Your Ref: OWPC26151
Our Ref: BN/18/20/PL 19-02-2020
Please ask for:
Maria Tomalova

Variation of condition 15 imposed under EG/29/13/ relating to condition 15 - to change the foul drainage scheme from Sewage Treatment Plant to Pumping Station with associated drainage works.

Former Brooks Nursery Eastergate

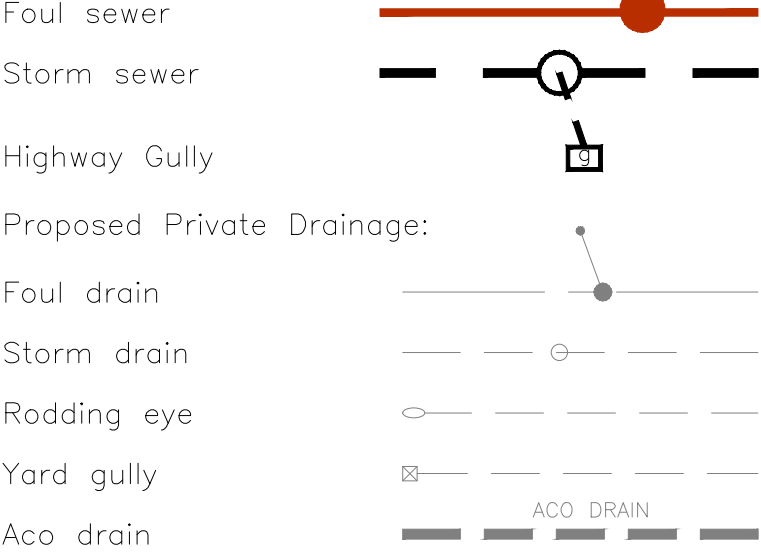
On the matter of the using a non return pumped 8 inch pipe joined onto a 56 year old gravity 6 inch clay pipe, this would cause problems. There could be blockages or the pipe could break, this would result in back up pressure and the resulting flow of raw sewage back into homes. It would continue as long as the sewage from Upton Brooks was being pumped. Some homes in Elm Grove South have already experienced such build up and have had foul sewage flowing into their homes.

The plan contravenes Arun District Council's Local Adopted Plan Policy QE SP.1 Quality of the environment by using small pipes. Also, the Parish Councils Neighbourhood Plan, section 5. Environment and Sustainability E32 Drainage. The plan did not include a map of Elm Grove South and this is where the problems will occur.
